**STATE OF WASHINGTON**  
**DEPARTMENT OF CHILDREN, YOUTH, AND FAMILIES**

February 10, 2025

Re: Project Parke Creek Landing Planned Unit Development (PD-24-00002) Associated Plat (LP-24-00004) and SEPA (SE-25-00001)

SITE DEVELOPMENT PLAN - PARKE CREEK LANDING  
A PORTION OF THE NW 1/4 & A PORTION OF THE SW 1/4 OF SECTION 34, T. 18 N., R. 20 E., W.M.  
KITITAS COUNTY, STATE OF WASHINGTON

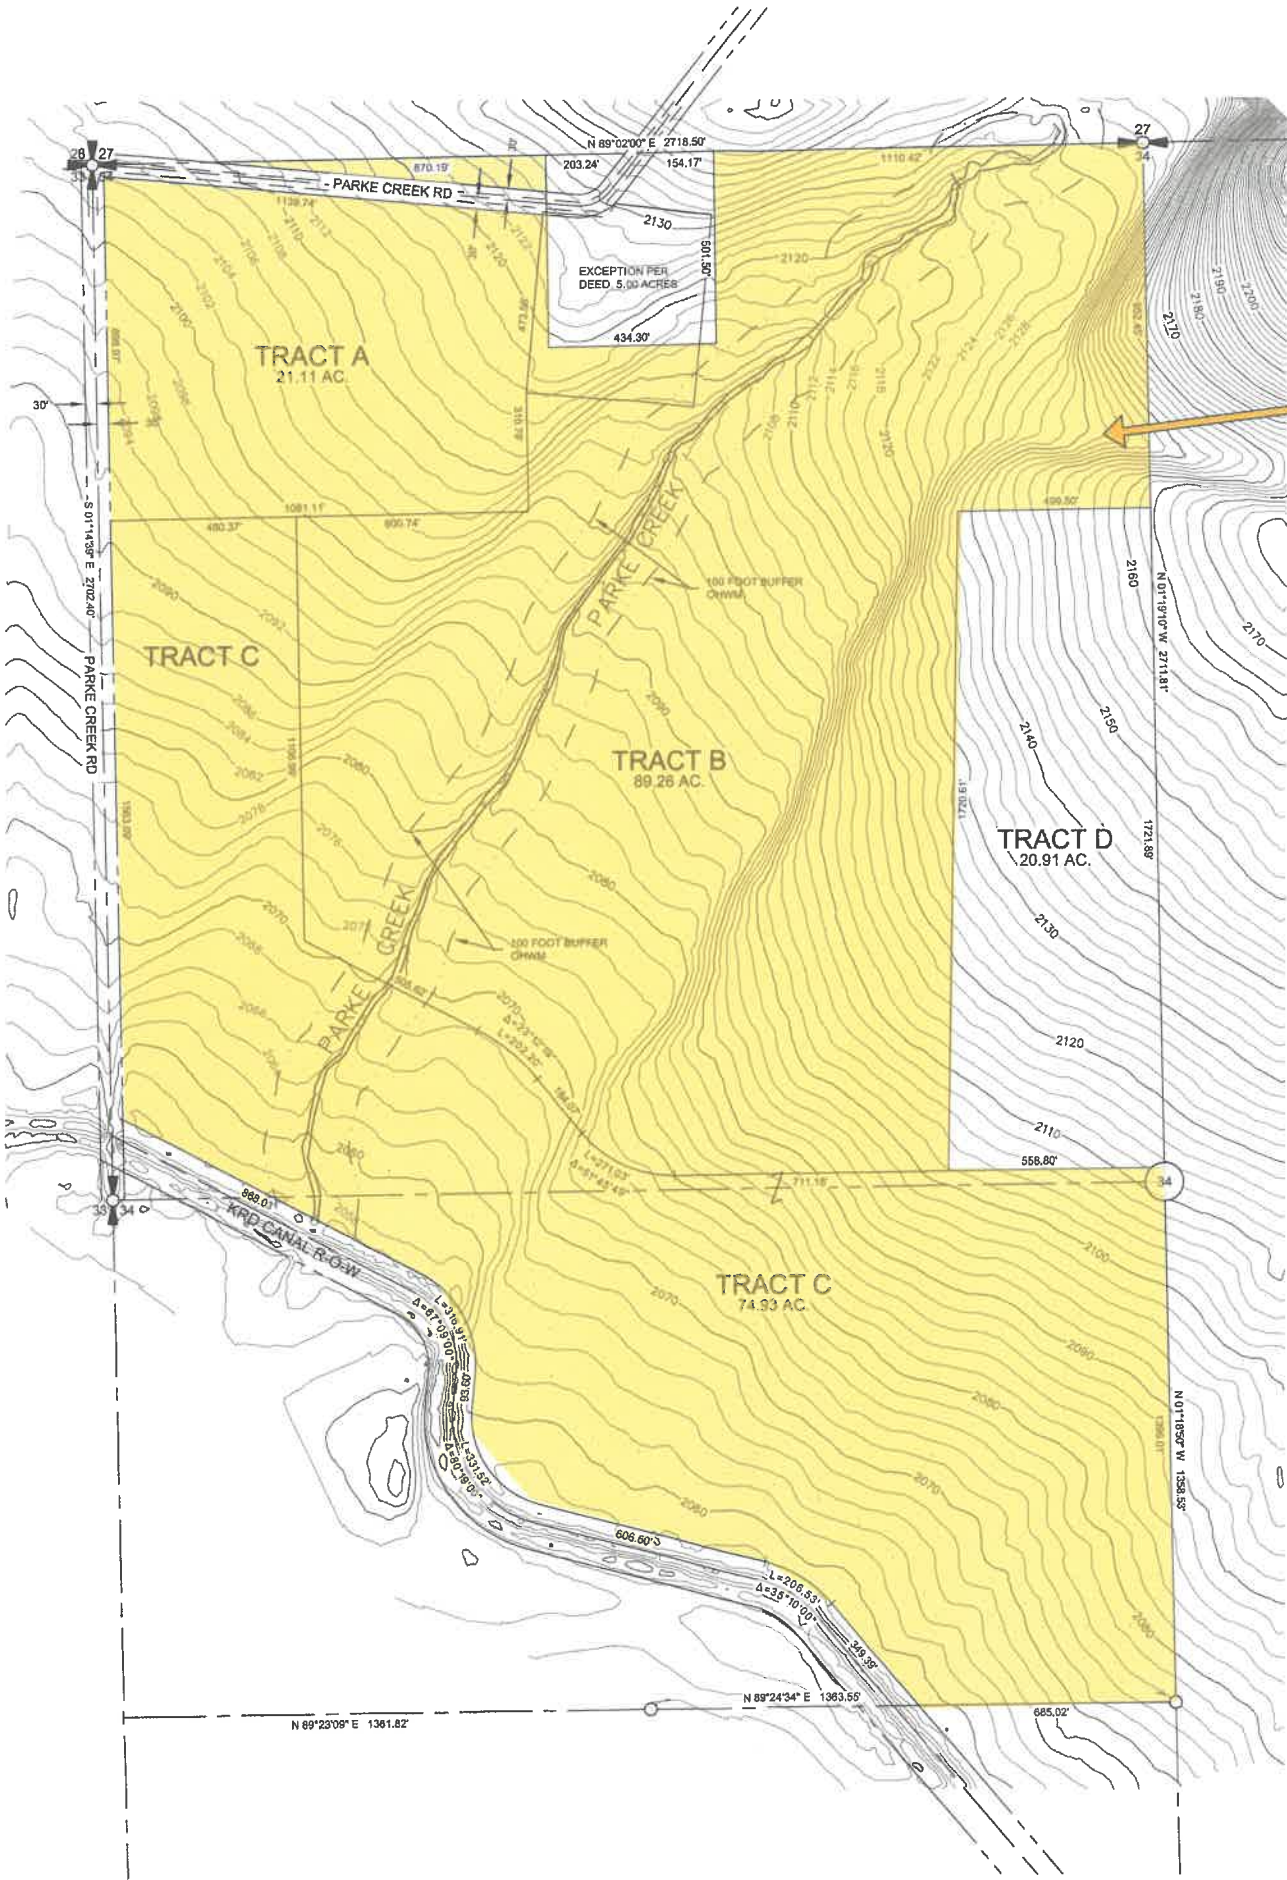
While we support the residential development aspect and welcome the planned RV storage area adjacent to our facility, we have significant concerns regarding the proposed Off-Road Vehicle (ORV) area. According to the current plans, this area would directly border our facility on two sides, potentially creating several challenges:

1. **Noise Impact:** The sound from off-road vehicles could significantly disrupt our therapeutic environment and daily programming.
2. **Air Quality:** During dry seasons, increased dust from vehicle activity could affect our facility's outdoor spaces.
3. **Operational Hours:** The timing of ORV activities could interfere with our youth's structured routines and rest periods.
4. **Light pollution:** The late hours of operation and increase of housing in this area would require the increase of excessive and artificial lighting, causing adverse effects and degrade environmental quality.

We respectfully request consideration of these concerns in the final planning process. Perhaps modifications to the ORV area's location, operating hours, or the addition of robust noise and dust mitigation measures could help address these issues while still meeting the development's recreational goals.
